90 North Lane East Preston. EP/60/19/HH.

With reference to the above planning application.

Proposed Rear Elevation (North)
1:100

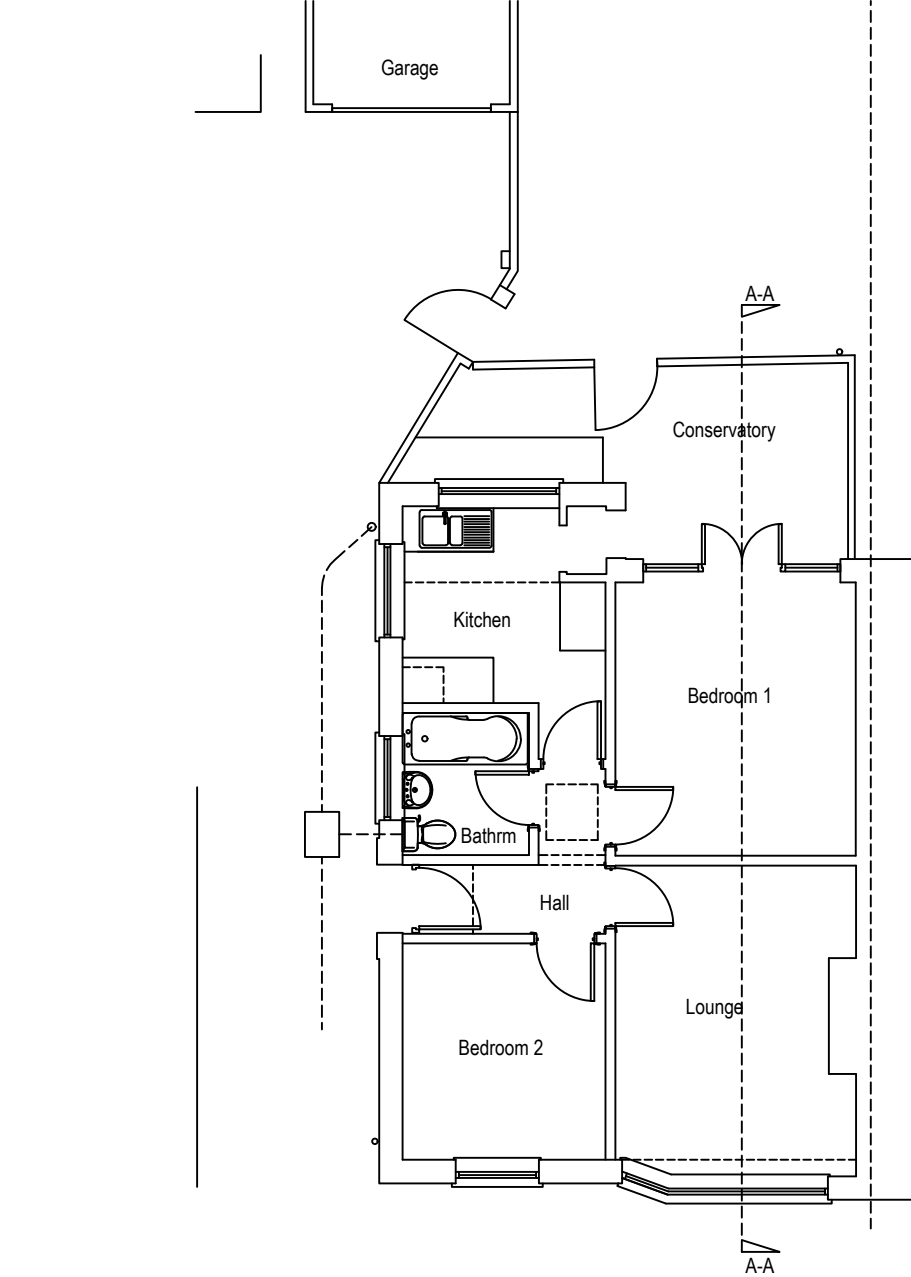
As I am affected by any building changes to the rear elevation of this address, will you please confirm to me the following points:

- that there will be no overall change to the height of the roof from the existing ground level.
- that the occupier will not change the original roof structure or raise the roof hip.
- that only dormer windows will be installed at the rear.
- that the occupier has no further

plans to change the rear structure or elevation of the building.
